DECISION DELEGATED TO HEAD OF PLANNING

Application No: H04-0973-22 **Applicant:** Magnum Group

Proposal: Erection of 11 dwellings comprising 7 town houses & 4 detached dwellings and demolition of existing buildings - re-submission of H04-0035-22

Location: 18 High Street Donington Spalding

PLOTS 1- 4

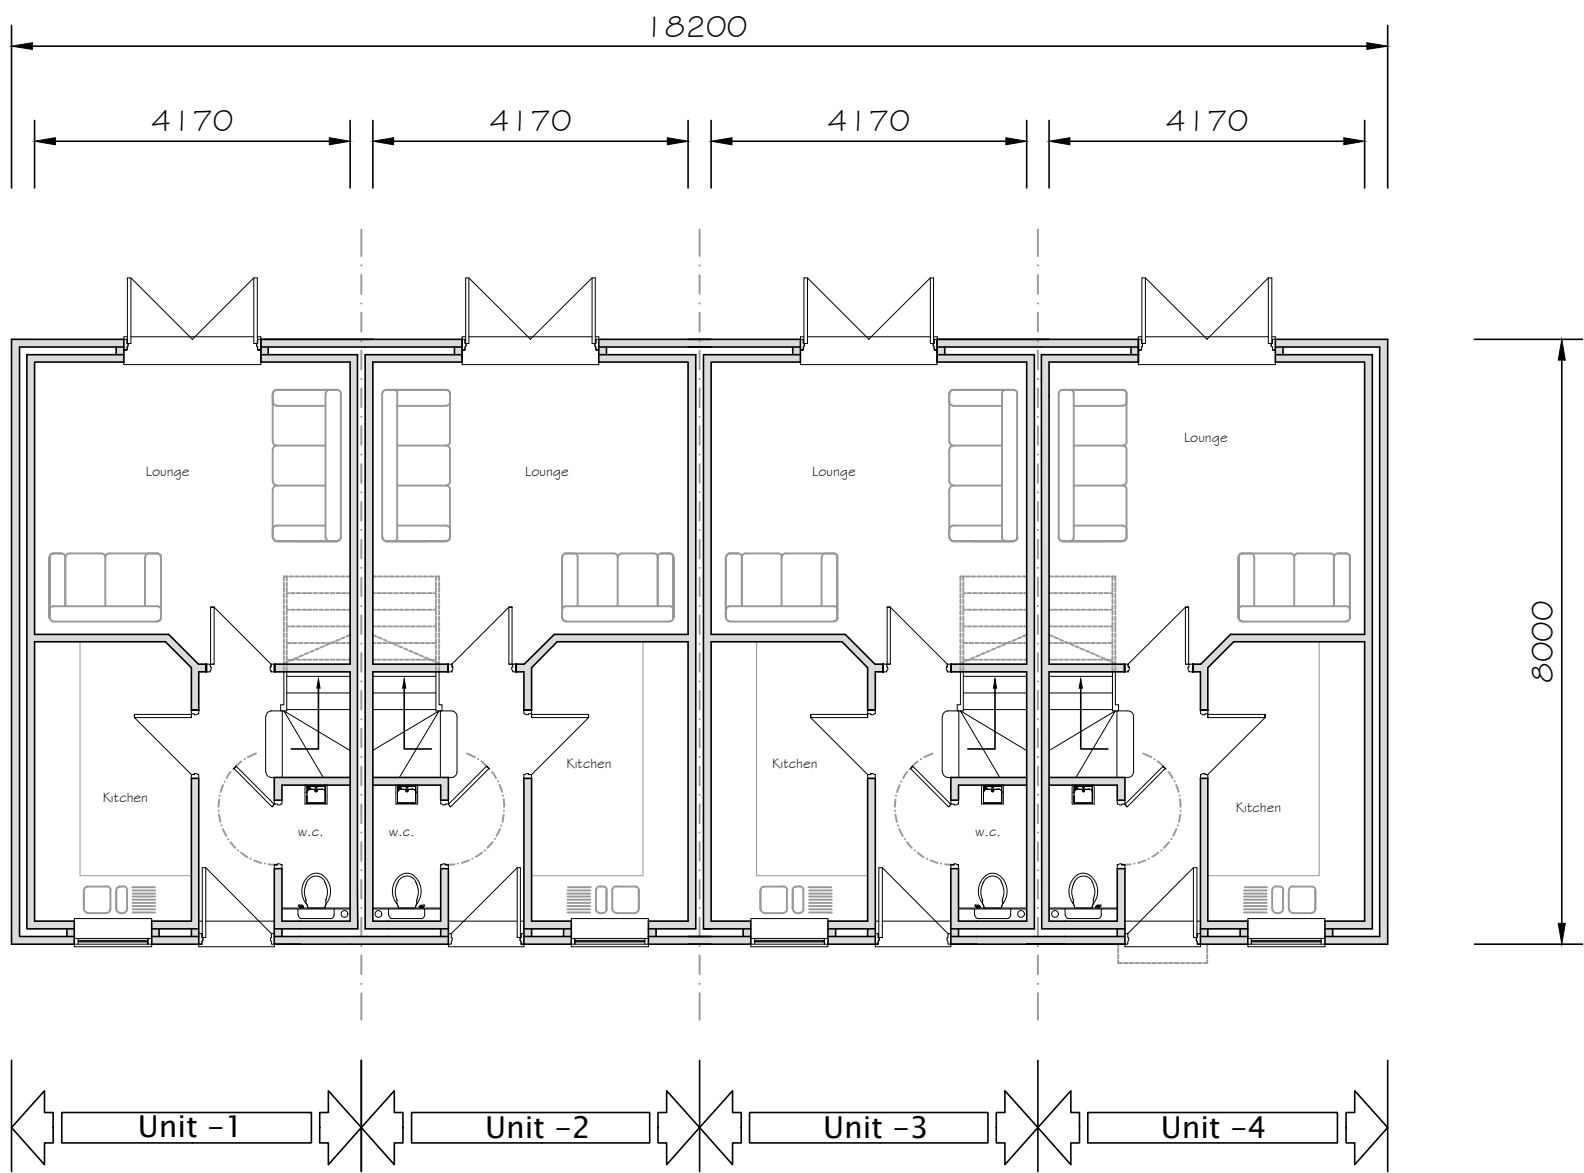
However, as mentioned in my former consultation, the materials of construction do not appear to me to be fully appropriate to the setting. In particular, the proposed and extensive use of UPVC for both windows and doors throughout is unacceptable under terms of Policy 29 above and under Section B, Subsection 4 of that policy. Given that even with appropriate design, inappropriate or poor materials can negatively impact upon the aesthetic qualities of a proposal, I find that it is crucially important to ensure that materials in this prominent setting are fully appropriate and sympathetic to their surroundings. I, therefore, would suggest that the officer requests that the application be amended to incorporate the use of timber doors and windows as well as black, metal rainwater goods throughout. I would then recommend the use of conditions requesting that the details of all doors, windows, and roof lights be agreed upon prior to their installation.

and setting and thus contrary to policy 29 of the SELLP. Furthermore, the use of UPVC openings without sufficient justification is also considered inappropriate and would again be contrary to policy 29. In turn the proposal would be contrary to policies 2 and 3 of the SELLP as well as part 12 of the NPPF.

PLOT 9 & 11

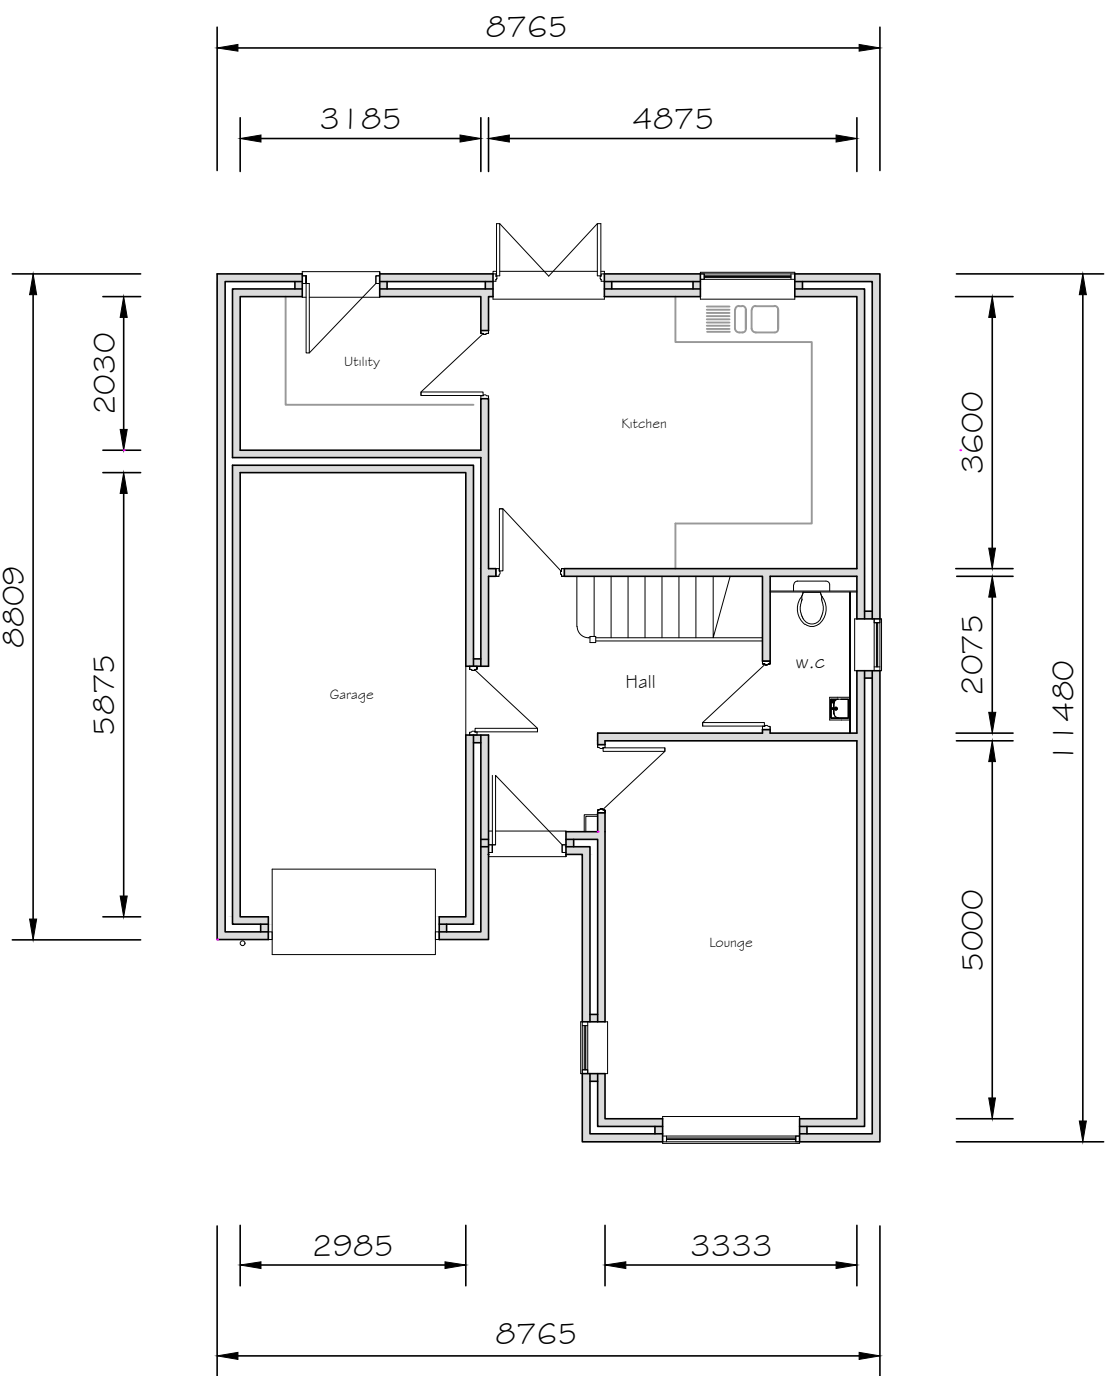
Furthermore, it appears that the applicant proposes to use imitation, concrete pantiles upon the rearward properties, this must be amended to incorporate authentic clay units, or preferably slates to match the street-front properties, as real slates represent the overwhelming vernacular in the immediate setting of the proposal site. Concrete tiles would again represent a breach of Policy 29, Section B, Subsection 4 of the SELLP.

Plots 9 and 11 are four-bedroom properties with integral garage. A red multi facing brick is again proposed and the roof dressed in a Sandtoft, with a terracotta finish. A gable feature extends from the main form of the principal elevation. Plots 8 and 10 are made up of the same materials and scale but handed opposite.
